DECISION DELEGATED TO HEAD OF PLANNING

Application No: H14-0629-23 **Applicant:** Mrs J Robinson

Proposal: Demolition of conservatory and erection of a single storey extension - Retrospective

Location: 30 Viscount Close Pinchbeck Spalding

TITLE REAR ELEVATION WITH EXTENSION				Louise Luck TEL -07931 569547	
SCALE	1:100	DRAWING NUMBER		Sheet Size	A4
DRAWN	Louise	PE11-3PS-30-8		SHEET	8 OF 8
DATE	01/08/2023			REVISION	.

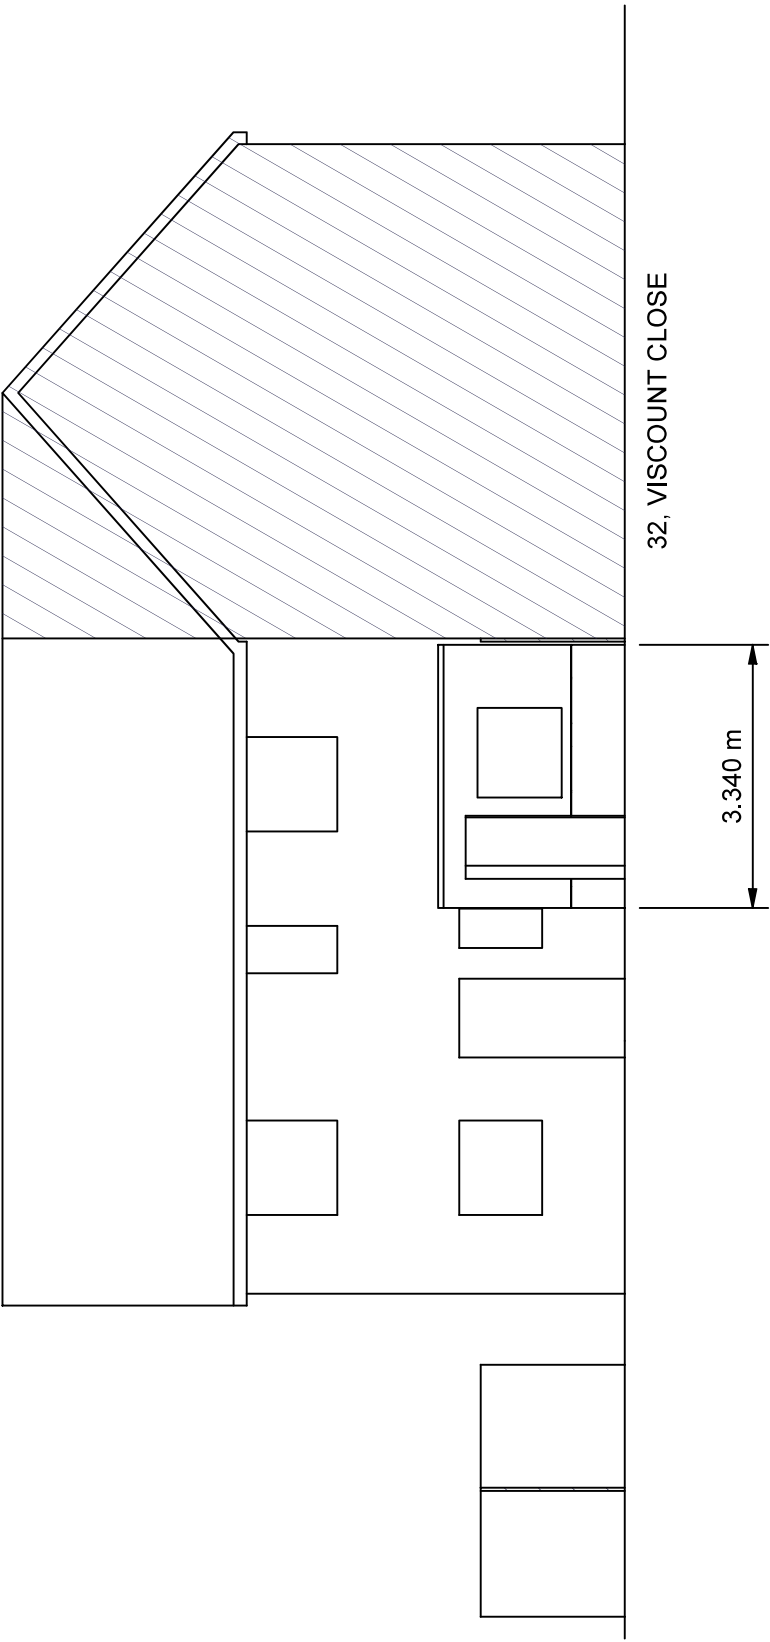
The extension will not overlook into neighbouring properties due to their only being one window facing the rear and due to it being a single storey extension the windows will be on the ground floor and therefore will not overlook any fences and result in a loss of privacy.

TITLE				Louise Luck TEL - 07931 569547			
SIDE ELEVATION WITH EXTENSION				Sheet Size A4			
SCALE		1:100		DRAWING NUMBER			
DRAWN		Louise		SHEET		7 OF 8	
DATE		01/08/2023		REVISION		.

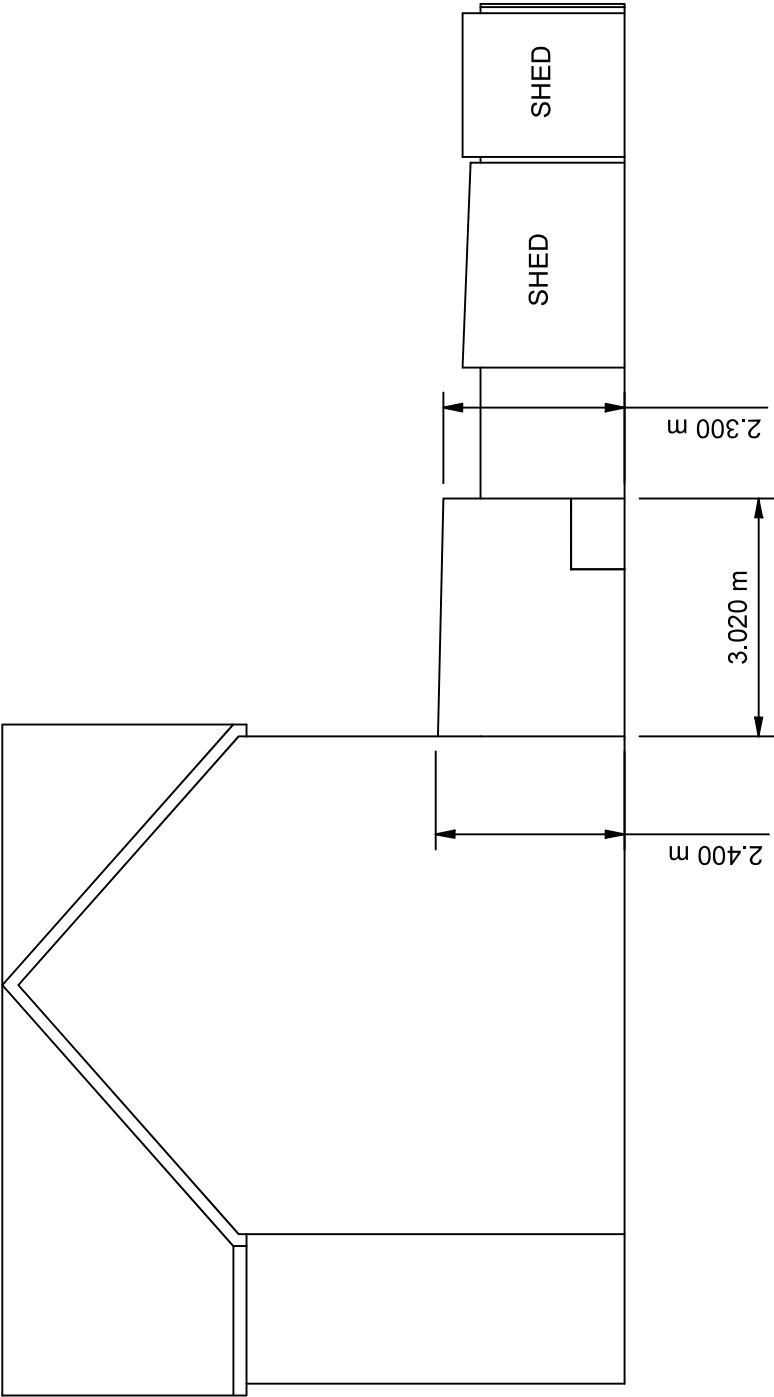
The height of the extension slopes down from the rear to the front, the rear height is 2.4m where as the height at the front is 2.3m. It protrudes from the rear elevation by 30.2m and is 3.34m wide. These measurements are considered to be proportionate and acceptable when compared to the host dwelling.

The materials the extension has been built out of are not considered to match that of the existing dwelling. The lower part of the wall will be built out of brick with the upper part being timber frame, the previous conservatory was made of bricks with uPVC glass. The roof was previously also made of polycarbonate panels where as the proposed is made of timber frame with a felt exterior. The windows and doors are made of uPVC. As the dwelling and other dwellings in the area are, of course, made of bricks the extension being made of timber frame does match and therefore is considered to look out of character and could be seen to create visual discrepancies. The roof design is flat, this style is not favourable by LPA's. However, as the extension is at the rear and is small when compared to the existing house it will not be visible from the highway and therefore should not impact the locality or the street scene and can be seen as acceptable.

The height of the extension means that it will only be slightly higher than the boundary fence, 0.4m at the rear and 0.3m at the front, due to this it is not considered that the extension will cause any significant overshadowing and therefore won't result in a loss of light despite being built on the boundary. In any case, if the neighbour was to suffer from loss of light there are other windows at the rear that will allow natural light to come into the room due to them being connected internally.
